Erection of four terraced residential dwellings, garden/cycle storage sheds & associated car parking, utilising the existing access - This application may affect the character & appearance of The Steyne, Bognor Conservation Area & will affect the setting of a Listed Building

Former hotel tennis courts adj to The Royal Norfolk Hotel West Street Bognor Regis

BR/214/18/PL

Drg No: **RNHB.PLAN 5**

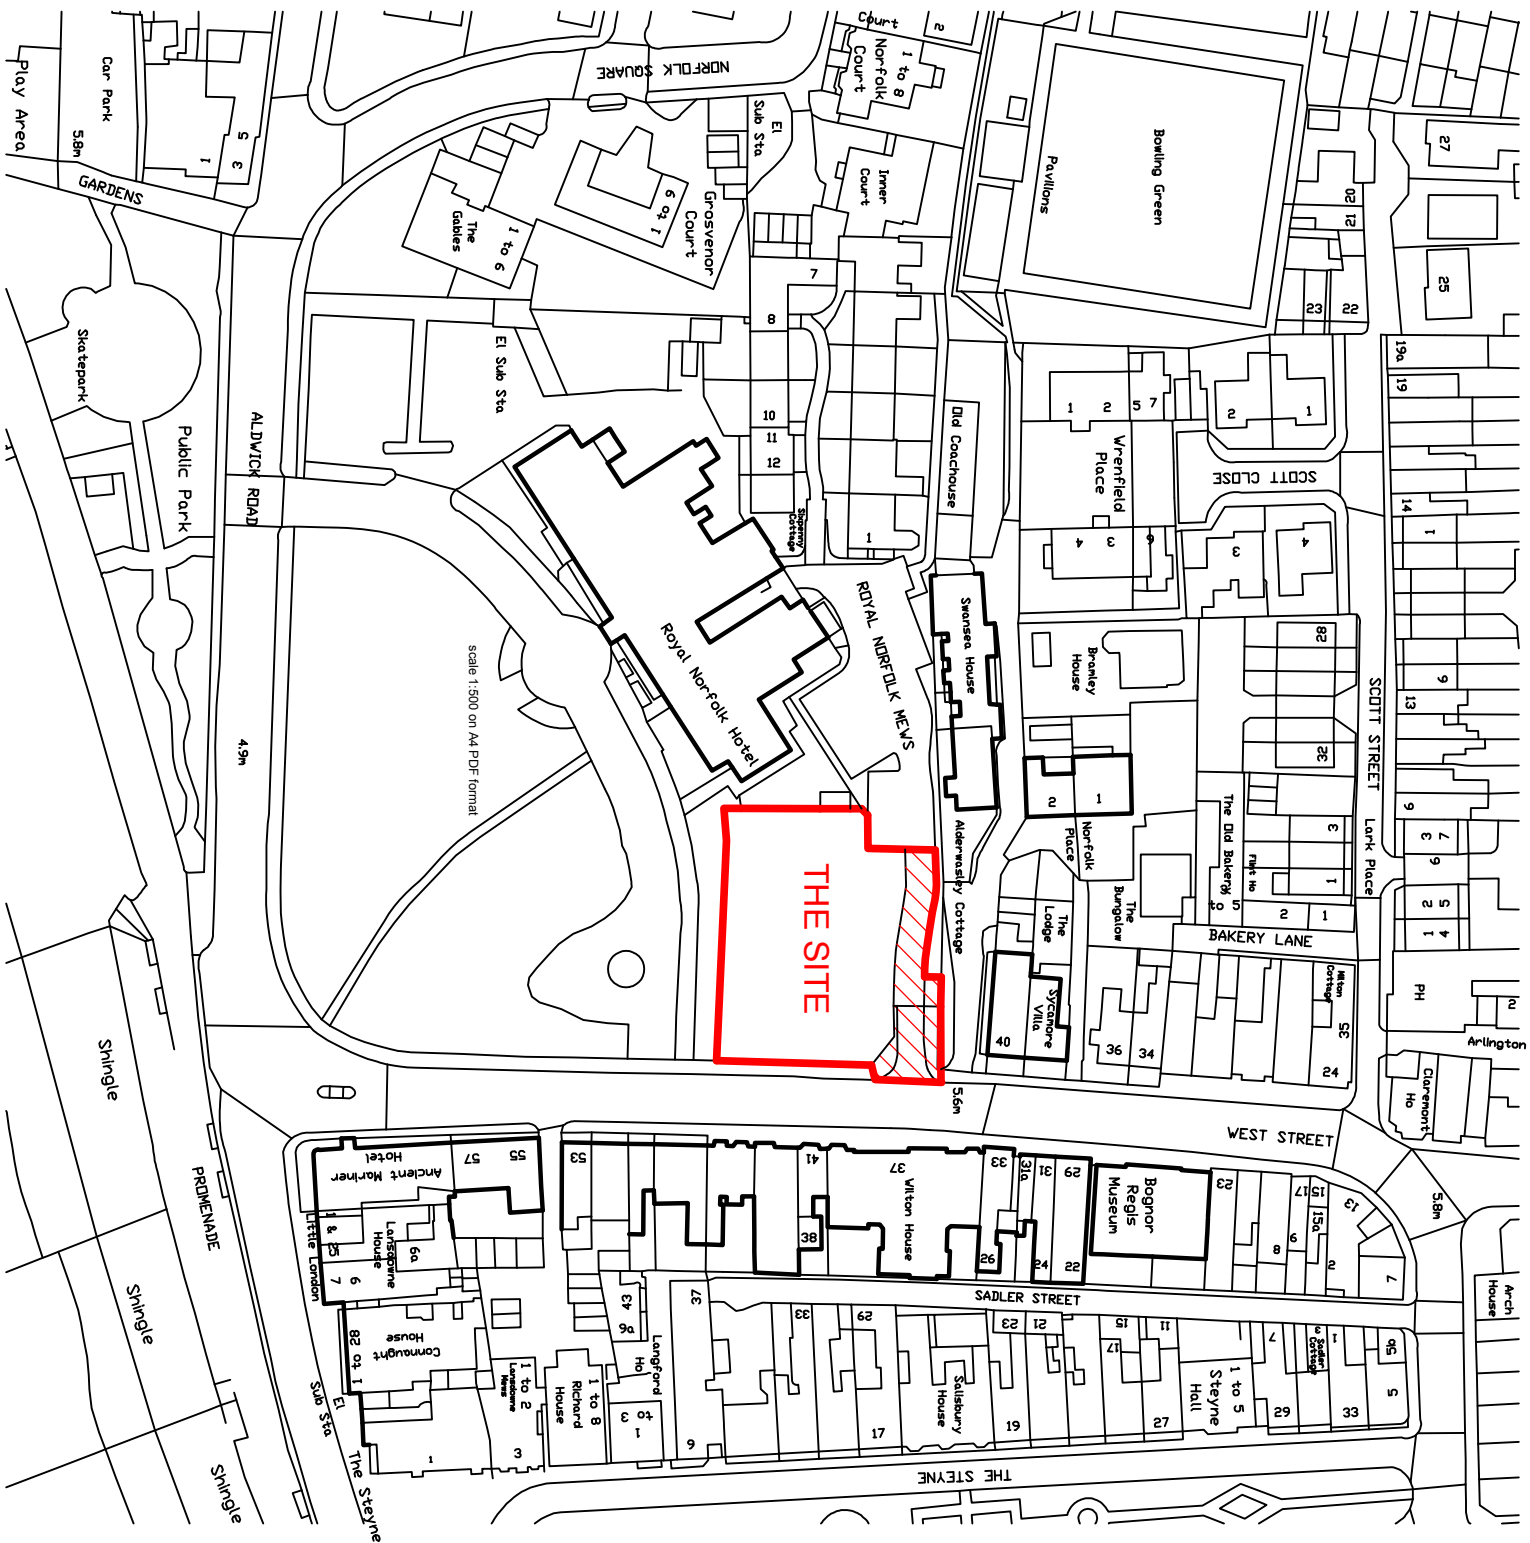
A meeting of the owners/shareholders of Royal Norfolk Mews Management Ltd. (RNMM Ltd), was held on the evening of 19.11.2018 to discuss the above application. A decision was taken to oppose this application because of the positioning of the entrance to the development proposed in the plan. It must be stated that a covenant in the deed of transfer of 8th May 2008, giving access to the transferor across the entrance road owned by the transferee, states:

An access was duly agreed, and a drop kerb installed on the transferee's land to allow the access. The Mews was then designed around that access. The plan proposed for the new development ignores this and places a new entrance further west, adjacent to, and detrimental to, the visitor parking owned by RNMM Ltd.. This cannot be agreed and the existing entrance must be used and the plan amended.
